**WEST SUSSEX COUNTY COUNCIL
PLANNING SERVICES CONSULTATION**

**SUBJECT: AL/8/18/PL - Erection of 2 No. 2 bedroom dwellings with
associated parking & landscaping.**

Land Between 8 & 10, Barnett Close, Eastergate, West Sussex, PO20 3UW

location plan &
proposed site plan

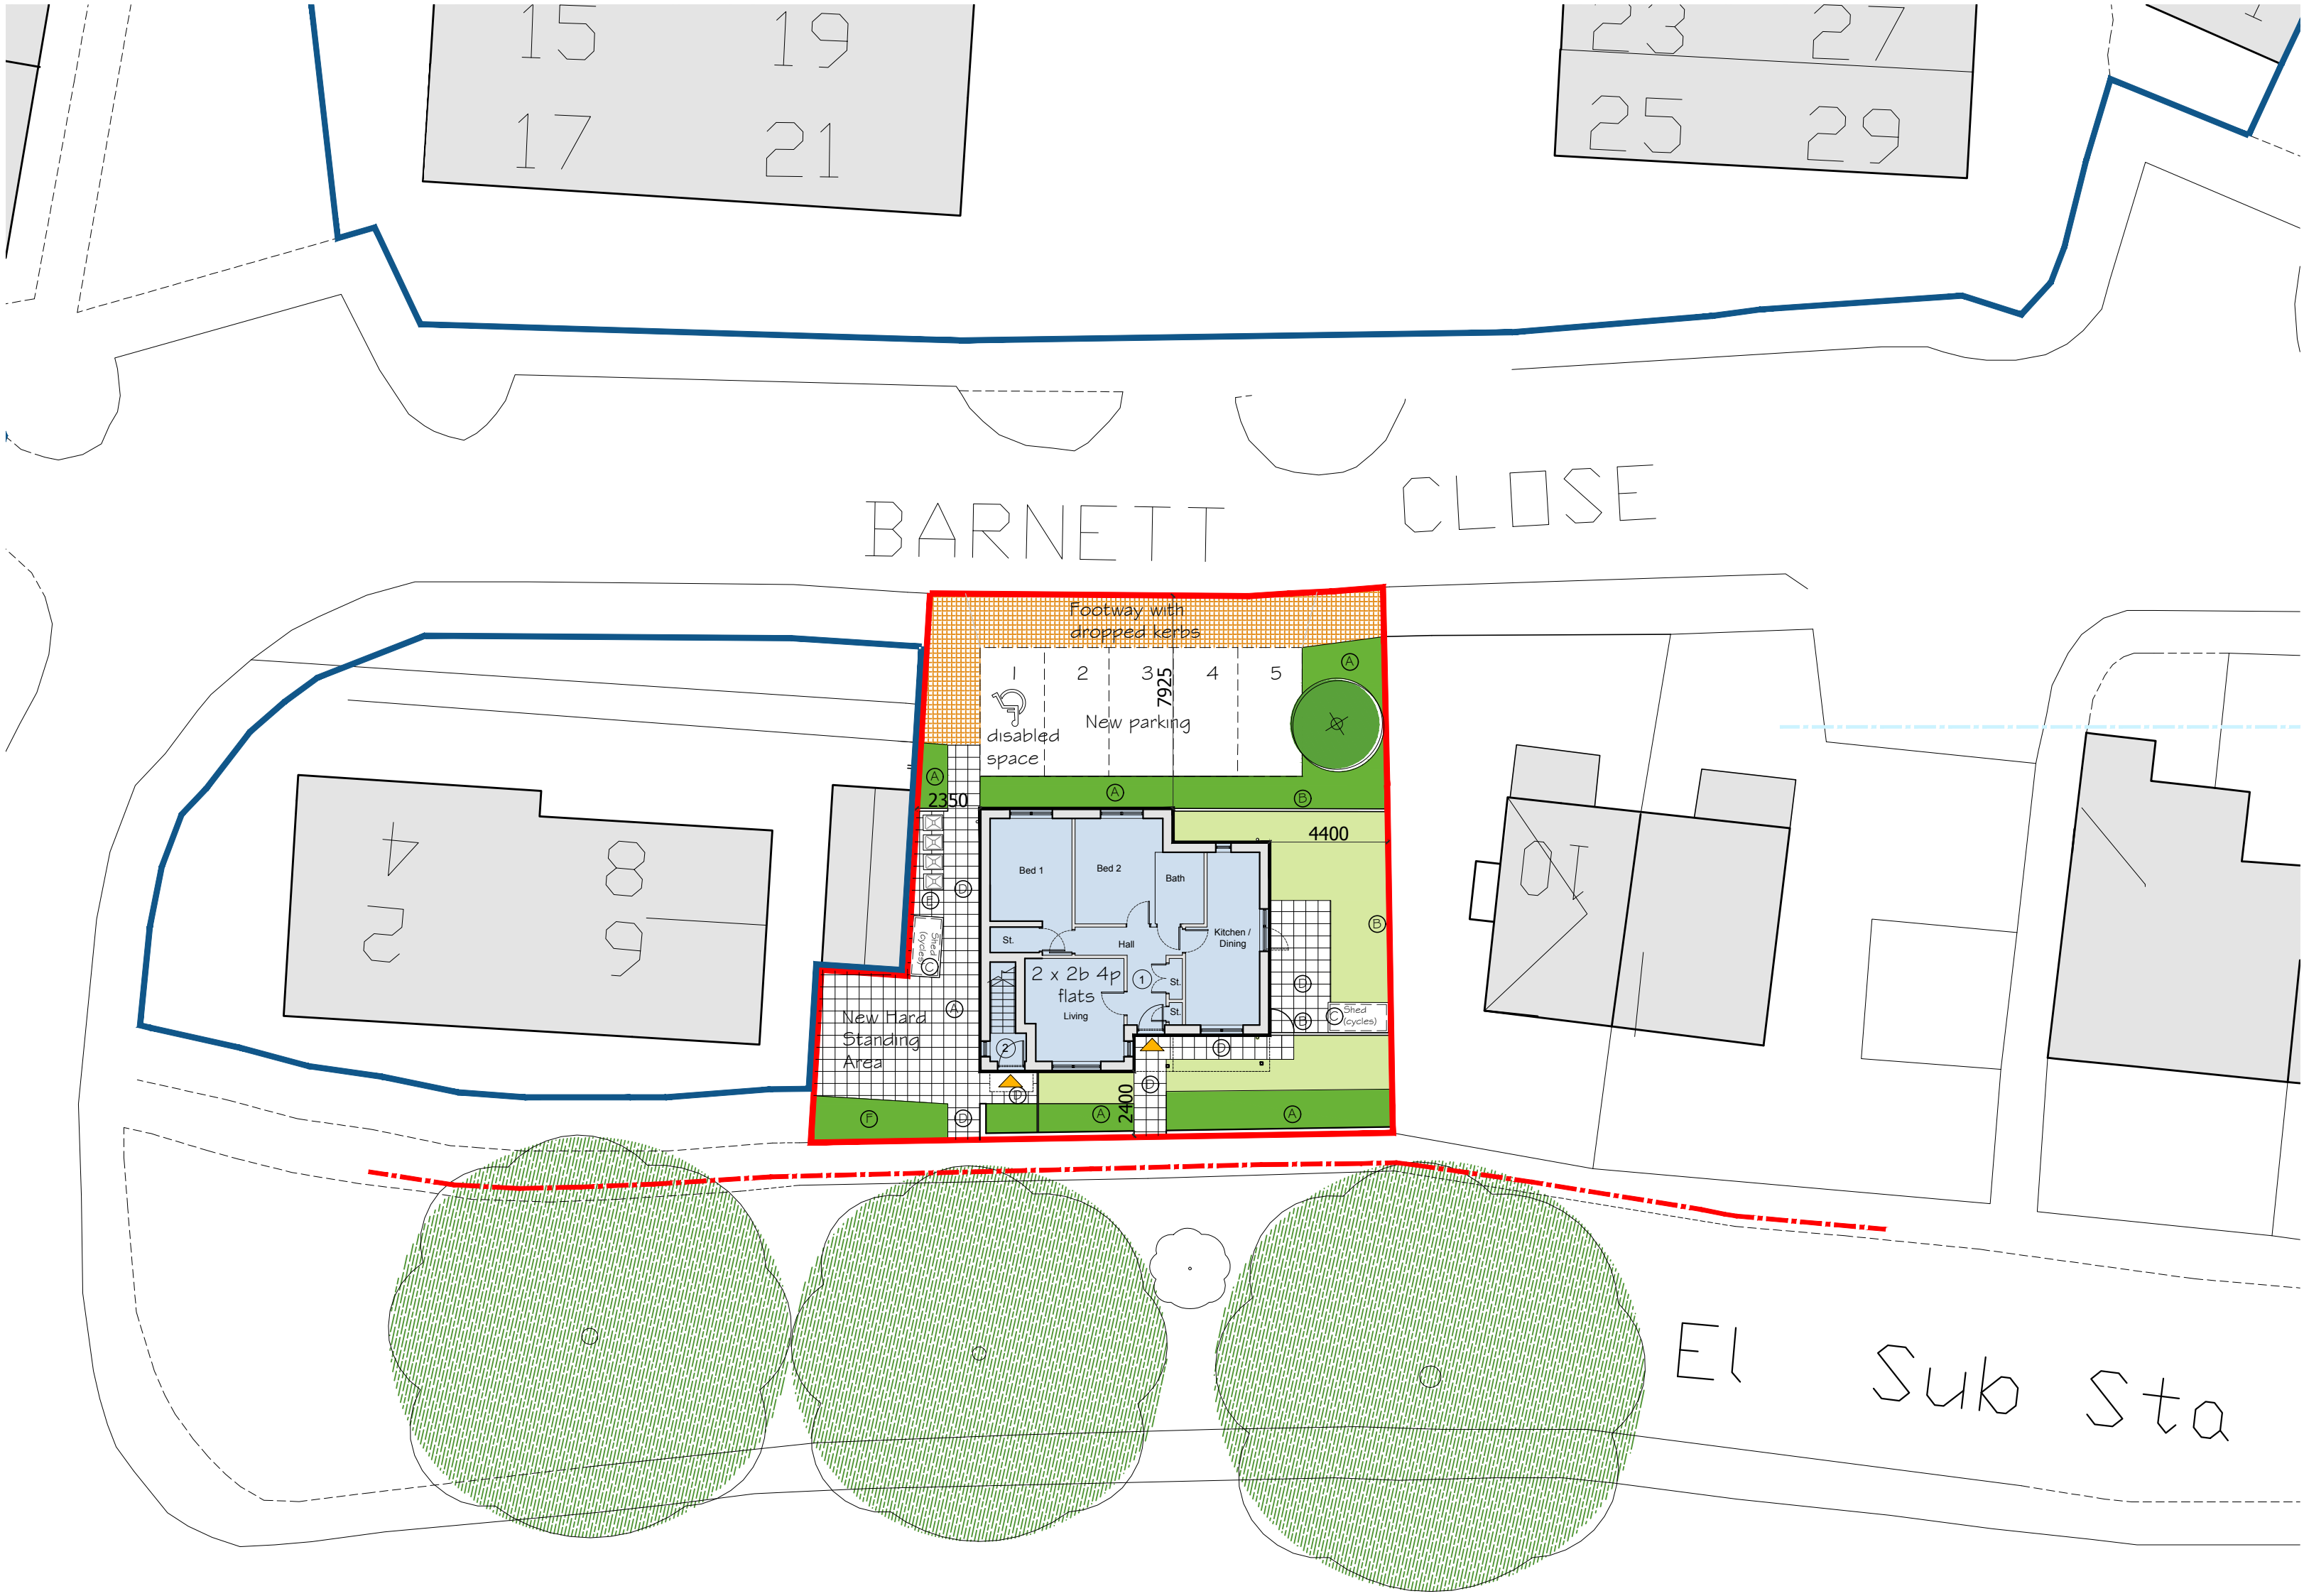
The remaining three spaces will remain unallocated for flexible use. It is noted one of the spaces is annotated as disabled. As per guidance within 'Inclusive Mobility' off street bay parking spaces for disabled access should be afforded additional level access width of 1.2 metres. This does not seem to be achievable given the proposed layout proposed.

Given the small scale nature of this scheme, which would not attract a dedicated disabled parking provision as per Manual for Streets paragraph 8.3.26, it would be advised this annotation is removed. Should the applicants wish to provide a dedicated disabled space it should be laid out as per the guidance within 'Inclusive Mobility' and the plans modified accordingly. I would accept such a matter could be dealt with via planning condition.
